Judge Orr Ranchettes, SP-17-011

Please accept the following comments from El Paso County Public Health (EPCPH) regarding the 40.67 acre, 7 residential lot development project referenced above:

JUDGE ORR
RANCHETTES
PRELIMINARY PLAN

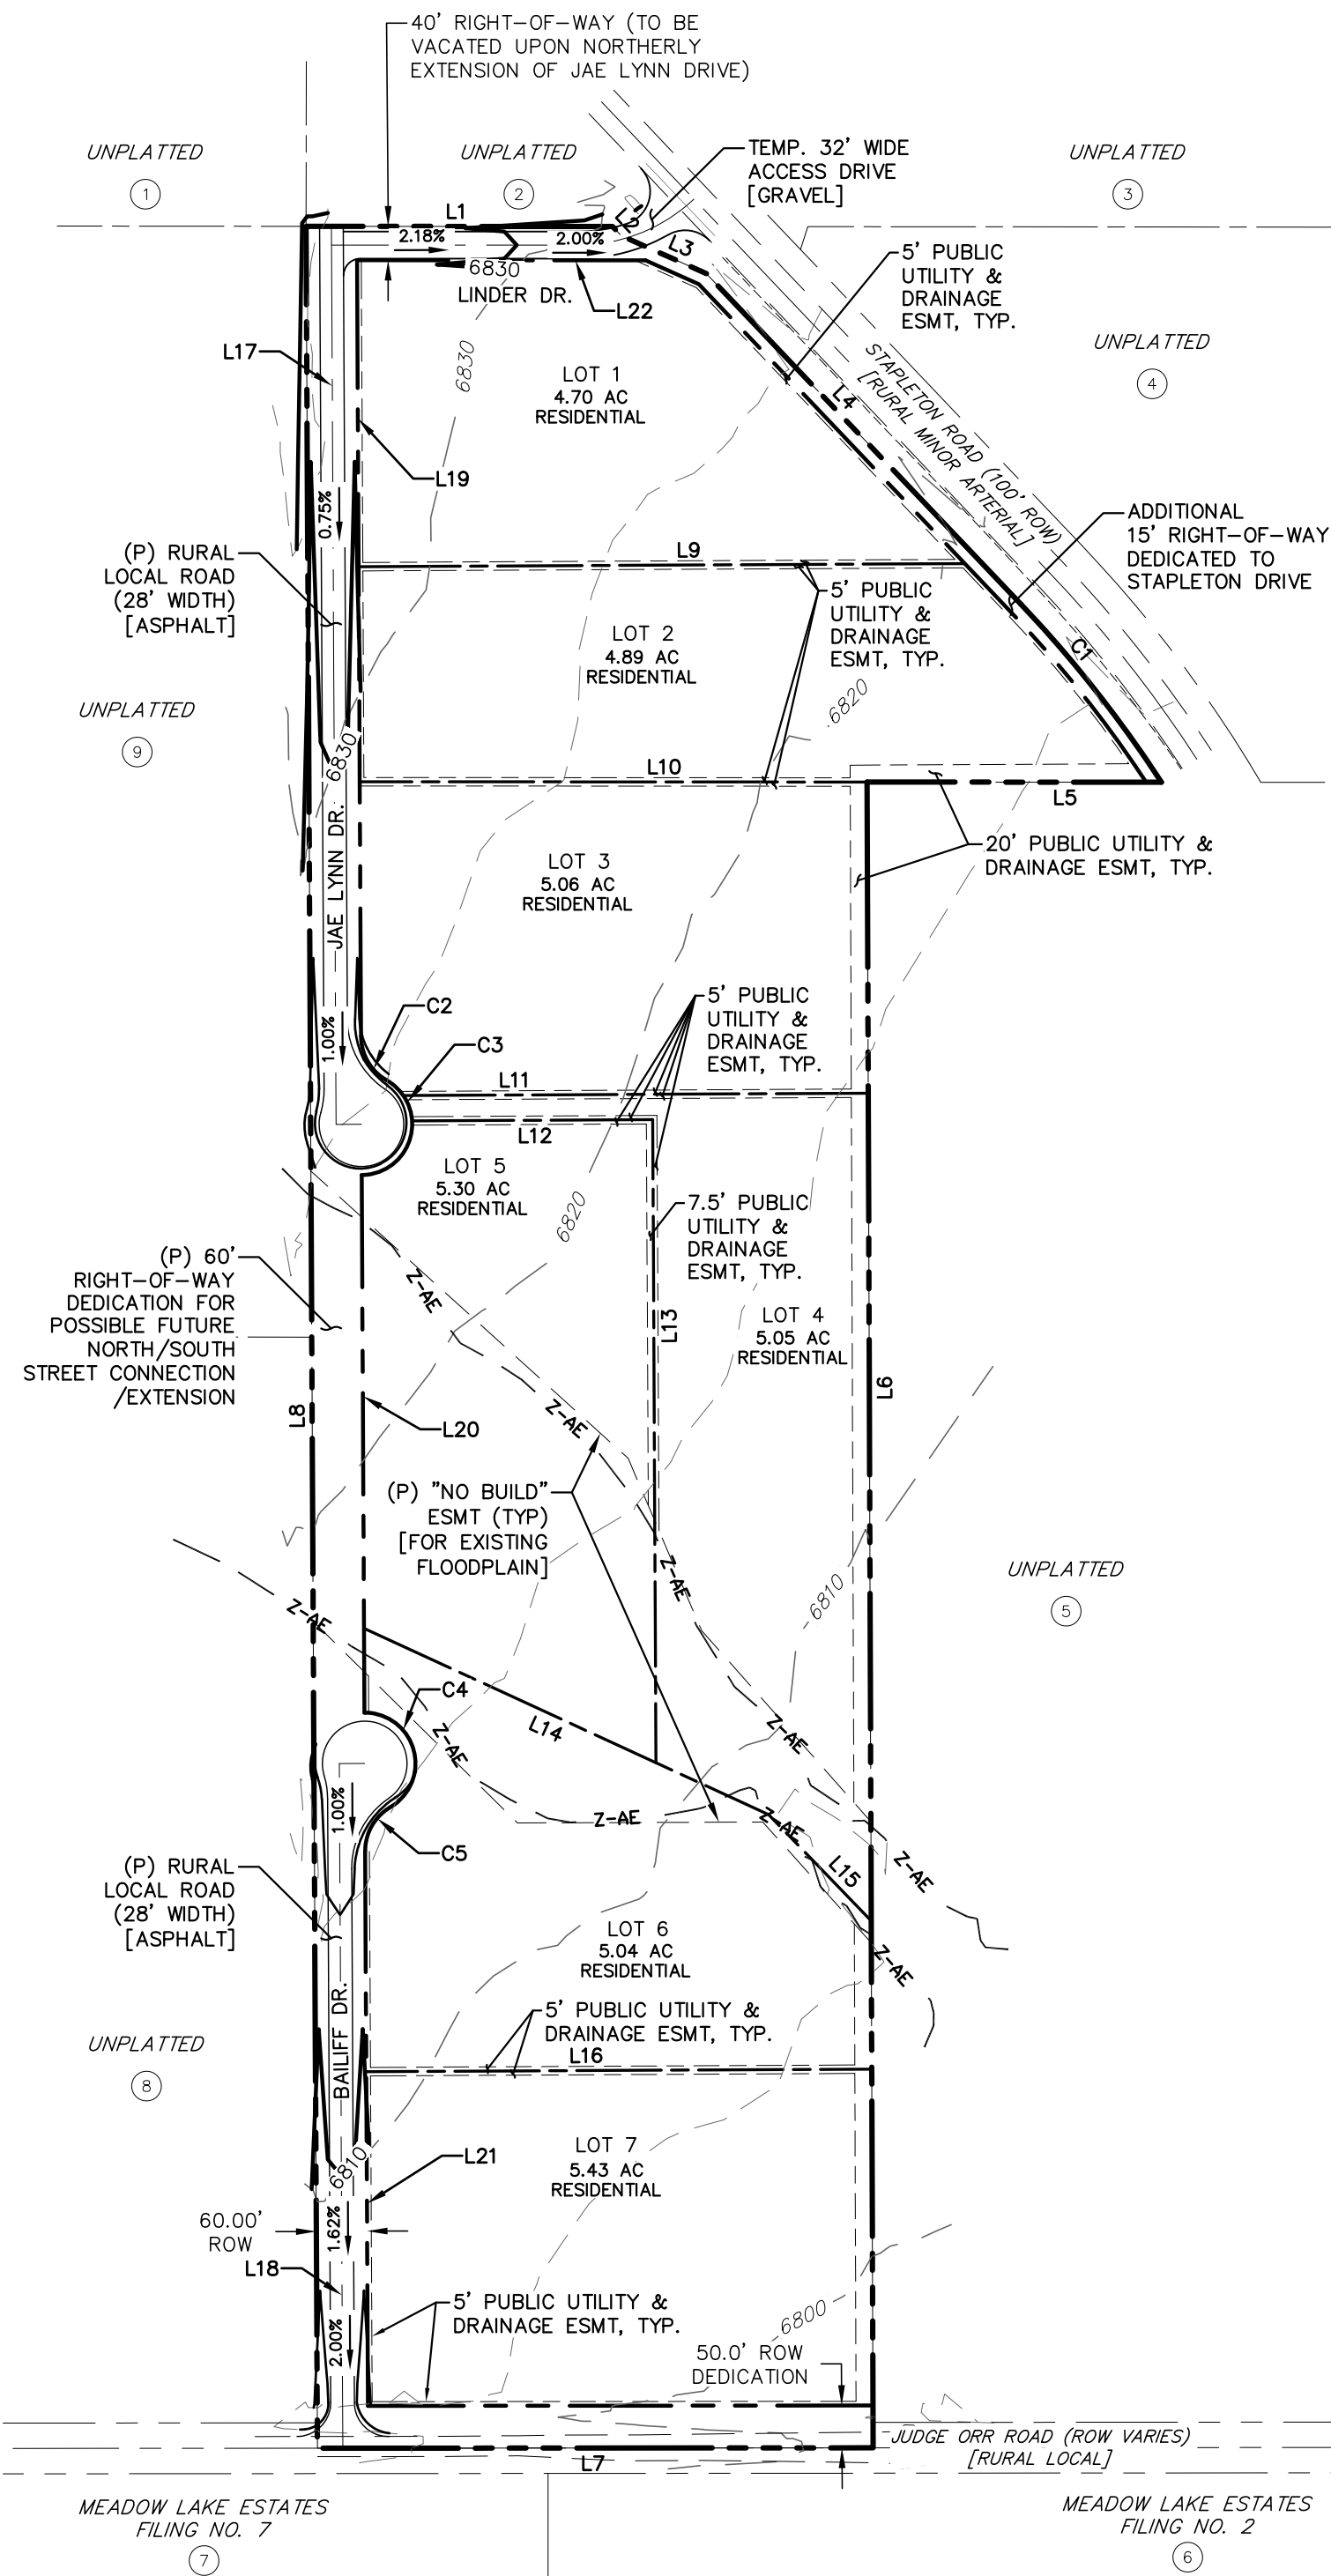
- **Careful planning is required when locating private wells and OWTS's on lots 5 and 4 because of the flood plain (no-build area) impact on lot 5 and the narrow shape of adjoining lot 4.**
